RE: 5770 and 5772 Old Stagecoach Rd.
Flying Horse North Maintenance building

This submittal is for approval of a site plan for the maintenance building for Flying Horse North. The 84.66 acre site is located along the south side of Old Stagecoach Rd. The included parcel is Tract L Flying Horse North Filing No. 1, recorded under reception number 218714238.

Letter of Intent.pdf Markup Summary

SD1.0
Site Development
Plan
Scale
1" = 20'-0"

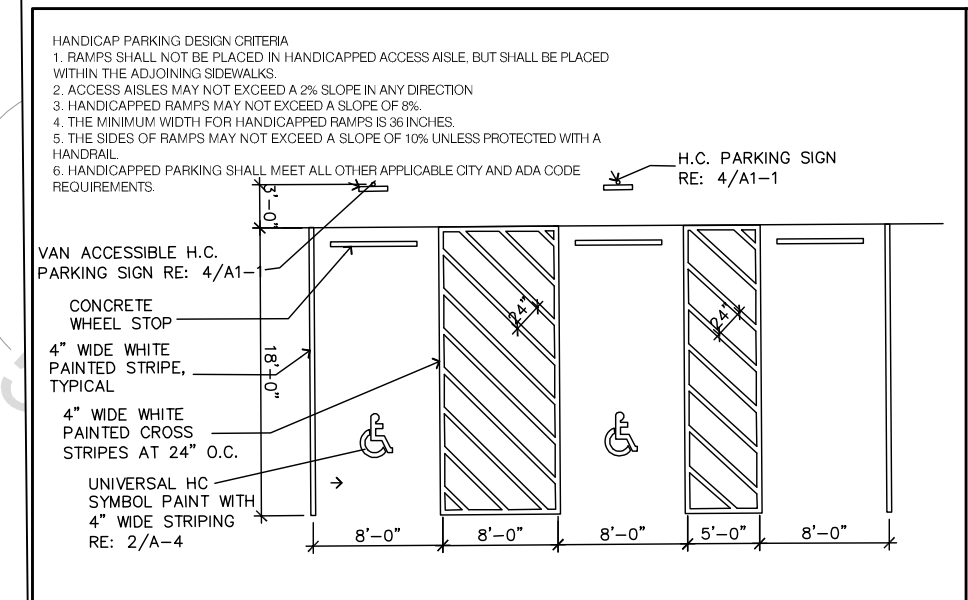
Define maintenance building and purpose
Include number of employees
Alternative parking ratio per section 6.2.5 1Avi of the land development code
Indicate that there will be no lights including building mounted
Indicate that there will be no signs
